STATE OF WASHINGTON  
DEPARTMENT OF ECOLOGY

June 19, 2008

Thank you for the opportunity to comment during the optional determination of nonsignificance process for the division of 40.65 acres into 8 lots, proposed by Donald Gerard [LP-08-12]. We have reviewed the documents and have the following comments.

GERARD PLAT
 PART OF SECTION 14, T. 18 N., R. 18 E., W.M.
 KITITAS COUNTY, WASHINGTON
 -- PRELIMINARY PLAT --

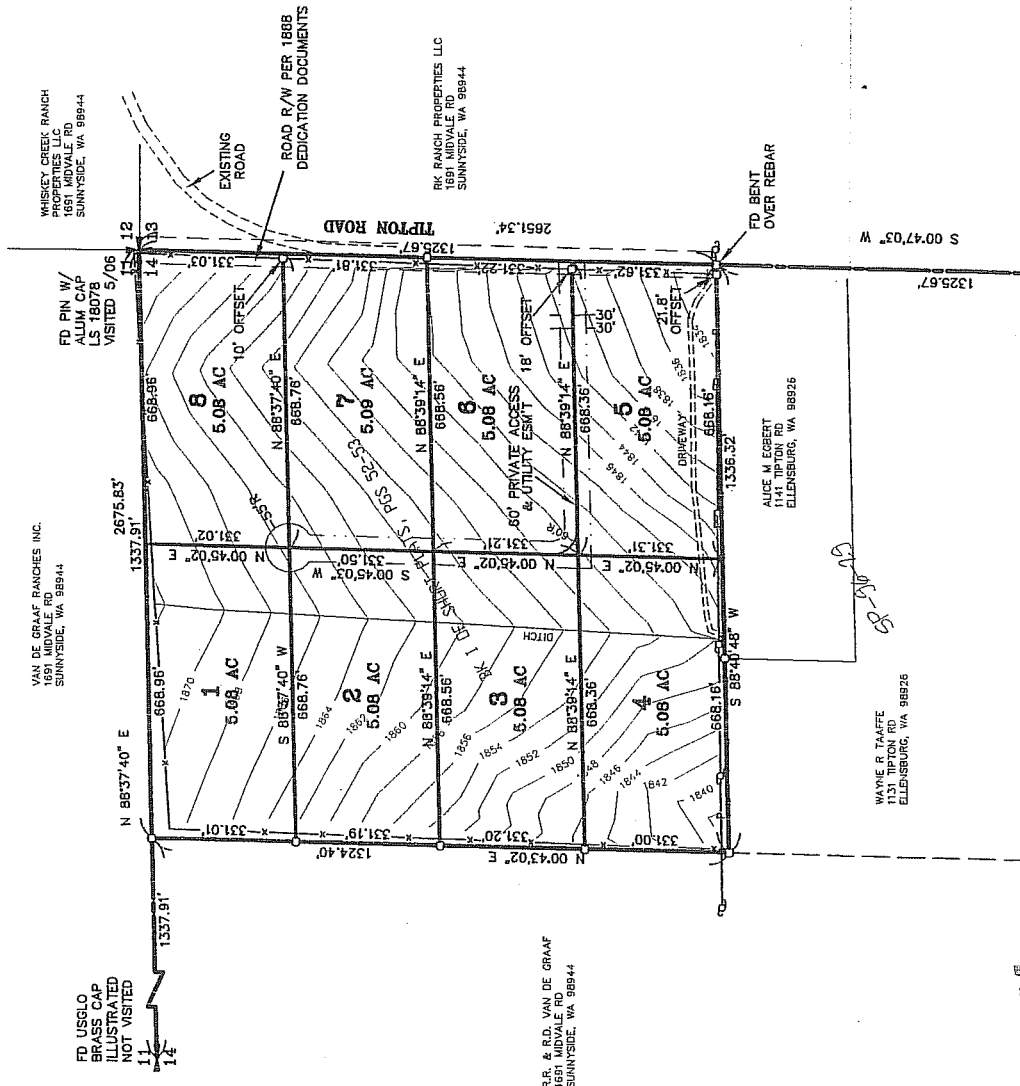
There is a concern about irrigation with a single groundwater exemption, which only allows up to ½ acre. With the proposed lot size, irrigation could easily be over 0.5 acres. If irrigation water is available through an irrigation district, know that the water purveyor is responsible for ensuring that the proposed use(s) are within the limitations of its water rights. If the proposal's actions are different than the existing water right (source, purpose, the place of use, or period of use), then it is subject to approval from the Department of Ecology pursuant to Sections 90.03.380 RCW and 90.44.100 RCW.

However, if irrigation water is not available through an irrigation district, Ecology encourages the use of covenants to help property owners stay within the groundwater exemption criteria until a valid water right is obtained for irrigation. For metering information, please contact Ken Schuster at (509) 454-4263. The key element will be to obtain valid irrigation rights.
